Your Ref: OWPC22381
Our Ref: P/29/19/HH 22-03-2019
Please ask for:
Amber Willard

Demolition of existing garage & outbuilding & erection of single storey side extensions
(resubmission following P/87/18/HH).

53 Cardinals Drive Pagham

sheet 2 a of 3

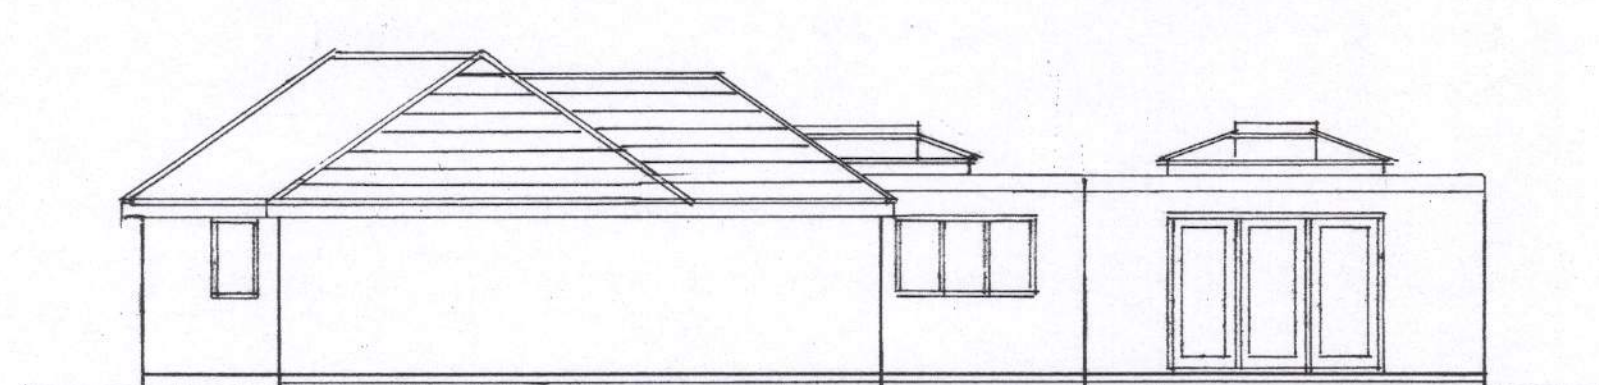
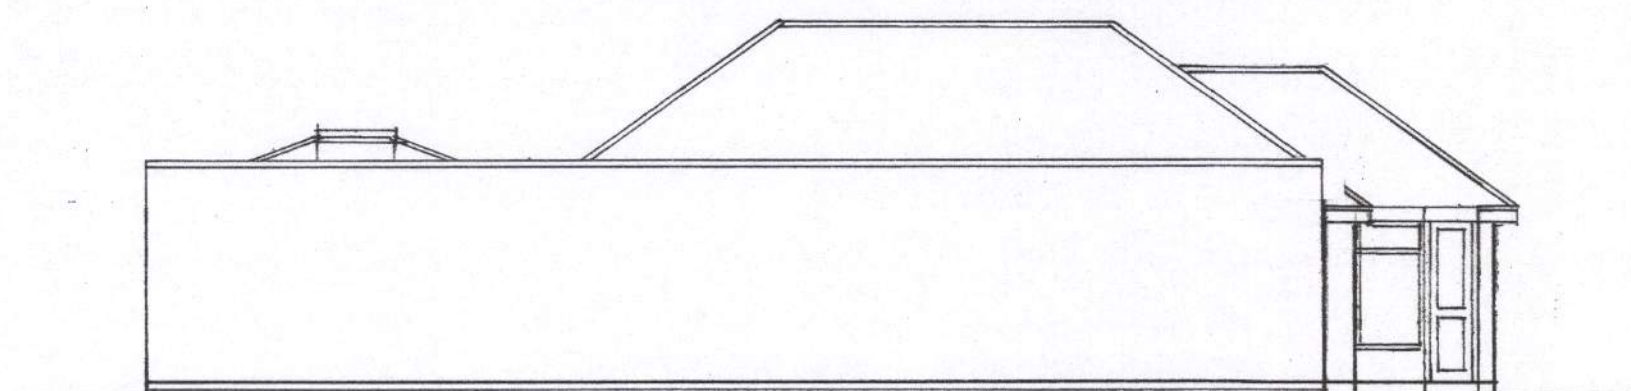
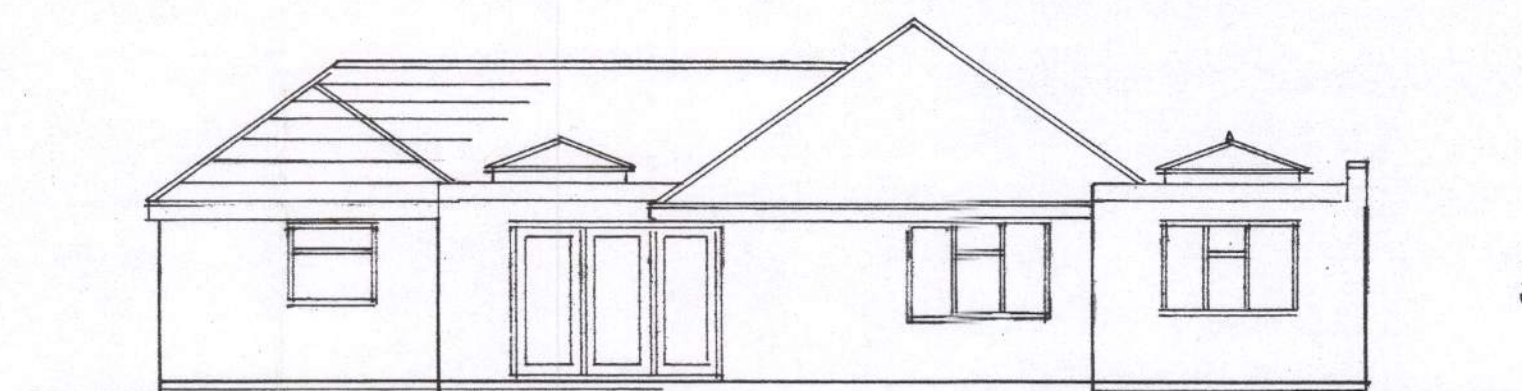
Prior to demolition, the garage and car port at 53 Cardinals drive was approximately the same height as 51 Cardinals drive which measures 2.4 meters (Ground to top of fascia board). I have various photos to demonstrate this fact, or you could simply look on Google street view.

At 51 Cardinals drive, the main entrance to the bungalow along with windows from the lounge (side aspect), the bathroom, the kitchen and the conservatory (side aspect) all directly face the north boundary wall of number 53 Cardinals drive. Where we previously had open views of the skyline, surrounding roof tops and tree tops it is now completely dominated by a very high wall that quite frankly looks like a commercial building.

In my opinion the new wall is very overbearing and overshadowing and is not in keeping with the surrounding buildings or indeed Pagham. I can't understand why it has been designed and built so high, the garage door is only 2.1 meters high so why does the building need to be so much higher than it was before.
